**Consultation Response from KC,
Ecology Unit**

2026/91286 2, Elm Street, Skelmanthorpe, Huddersfield, HD8 9BH

Discharge of details reserved by conditions 4 (dilapidation survey), 5 (Phase I Desk Study Report), 6 (Phase II Intrusive Site Investigation Report), 7 (Remediation Strategy), 8 (accordance with the Remediation Strategy), 9 (Verification Report), 10 (ecological enhancement measures), 11 (waste collection) and 14 (materials) on previous permission 2025/90583 for erection of rear dormers, raising of roof height and alterations to workshop to form dwelling

Drawing Title:
Proposed Location & Site Plan

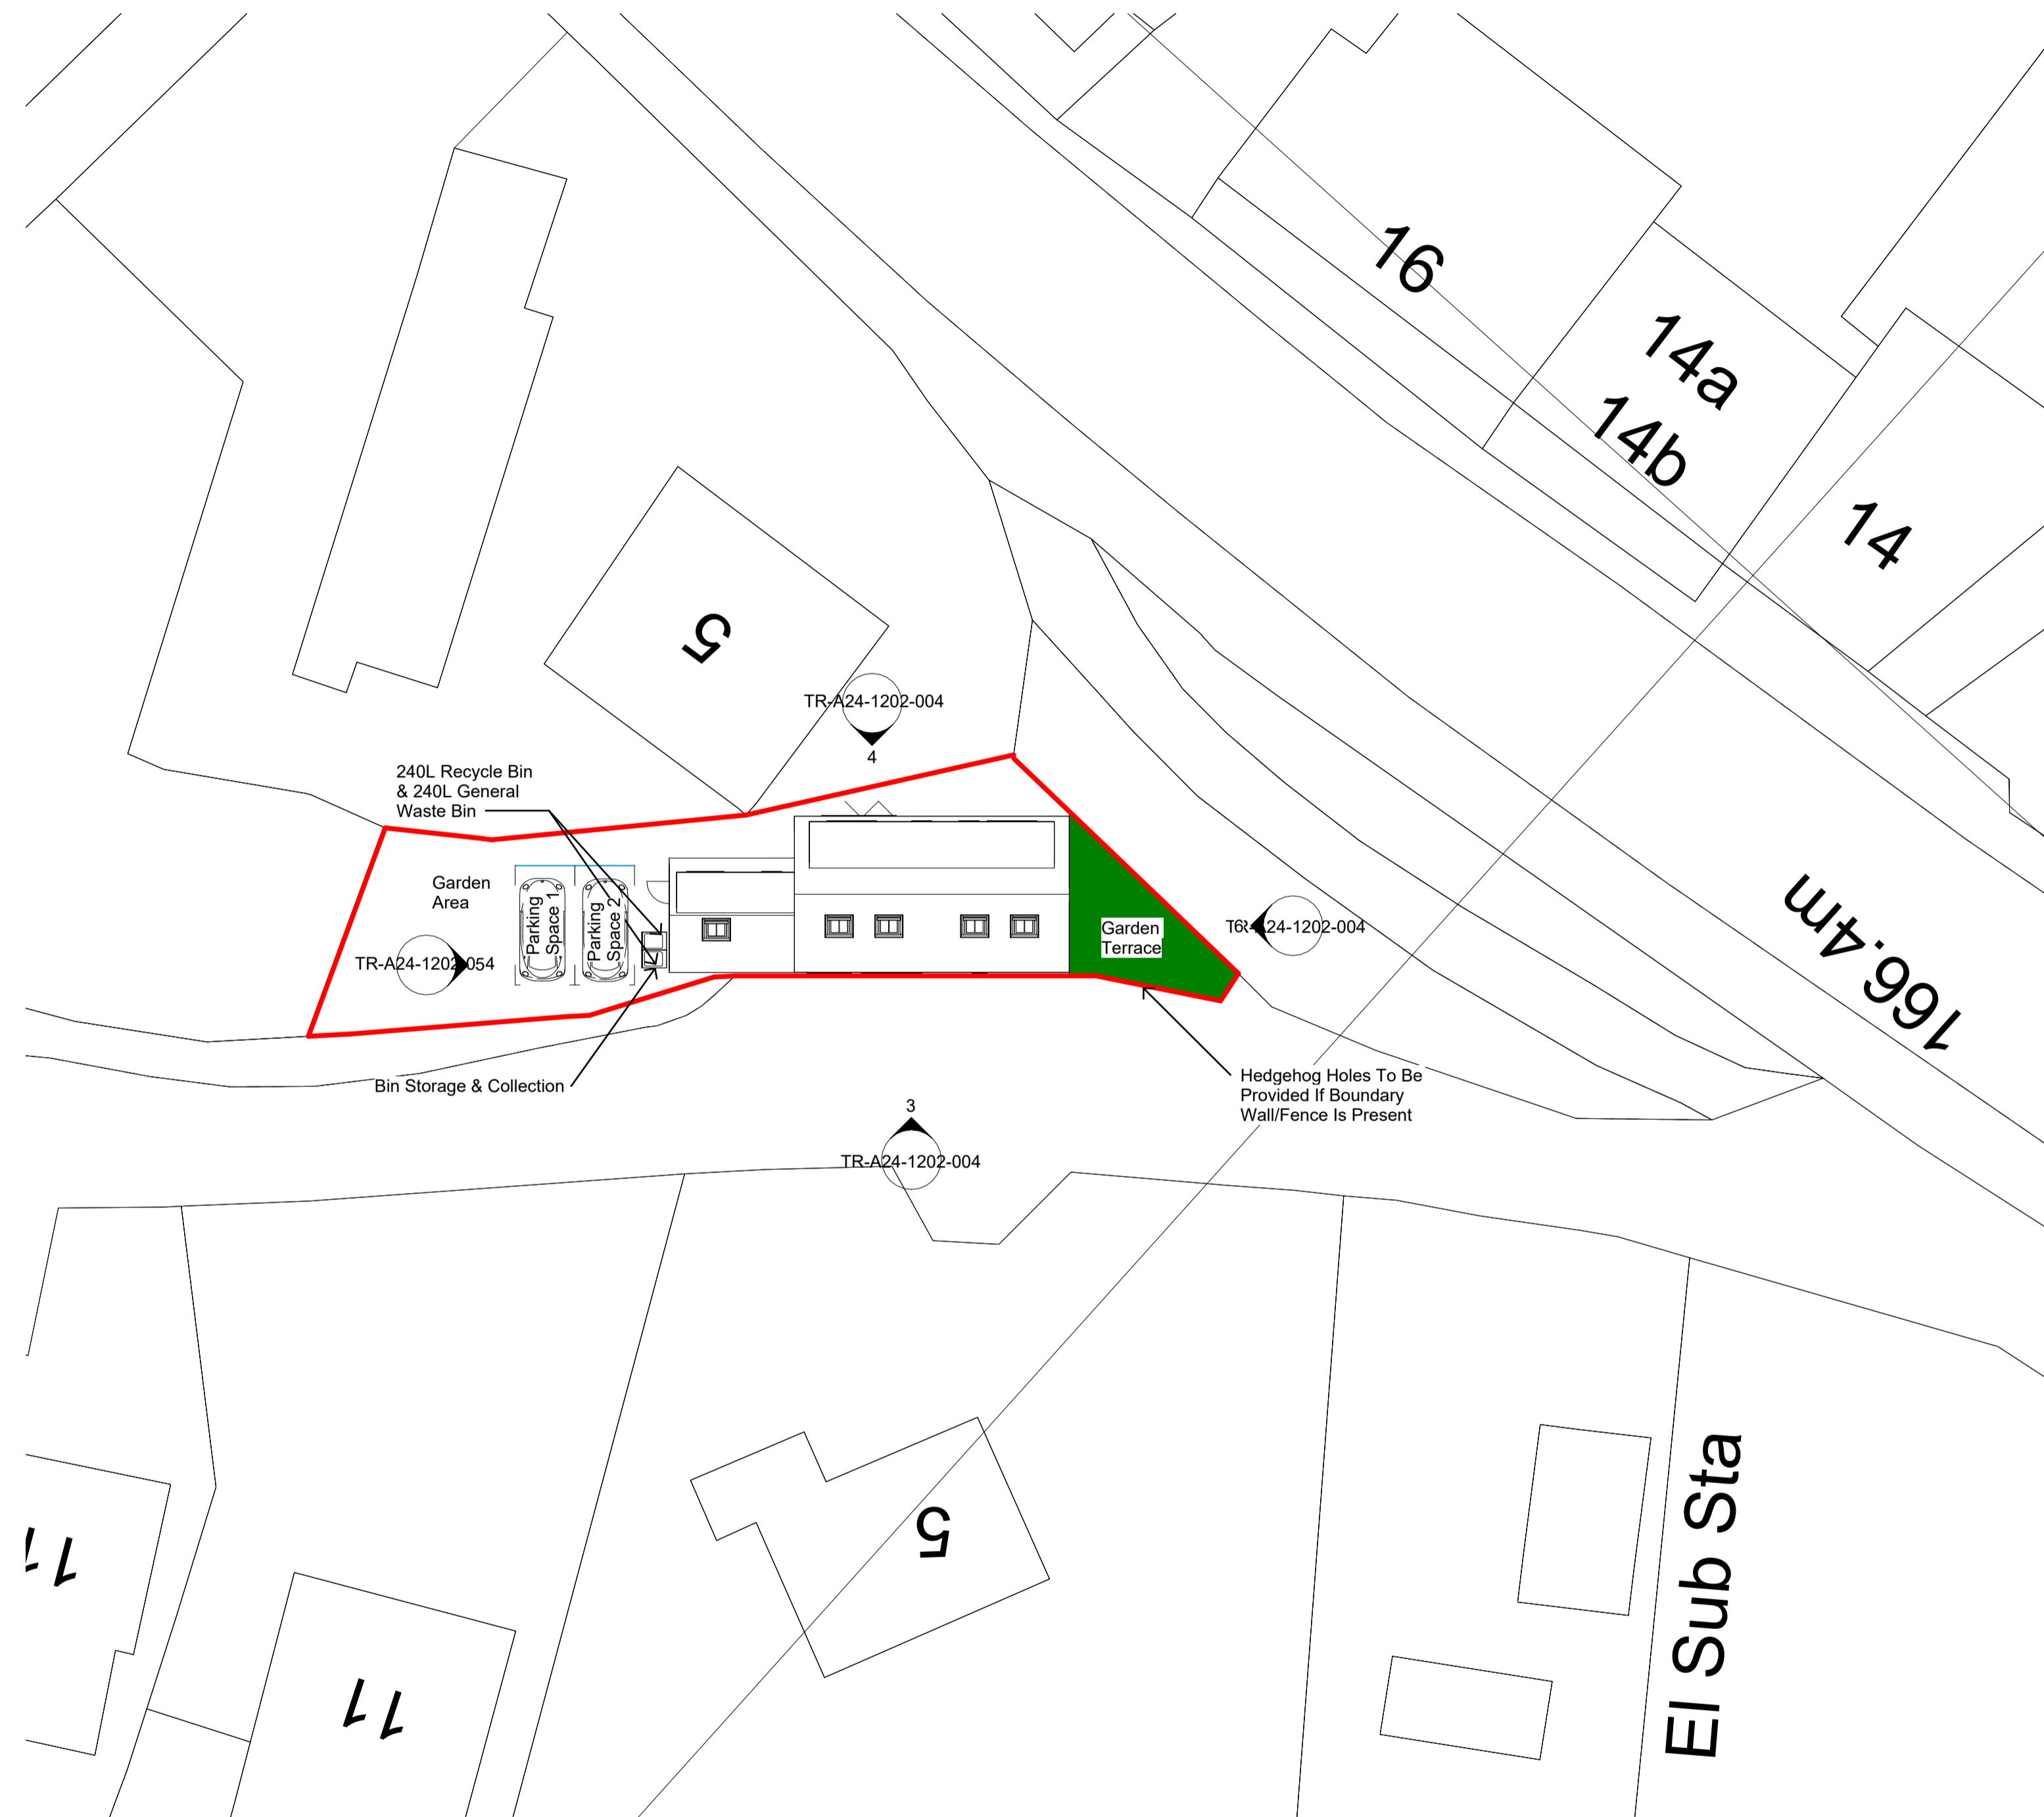
From the submitted plans I can see that details of hedgehog access holes will be required if the boundary is to be fenced. However, no information on the likelihood of this fencing proceeding is provided. Additionally, I cannot find any information on swift boxes to be included. This information is needed prior to the discharge of this condition.
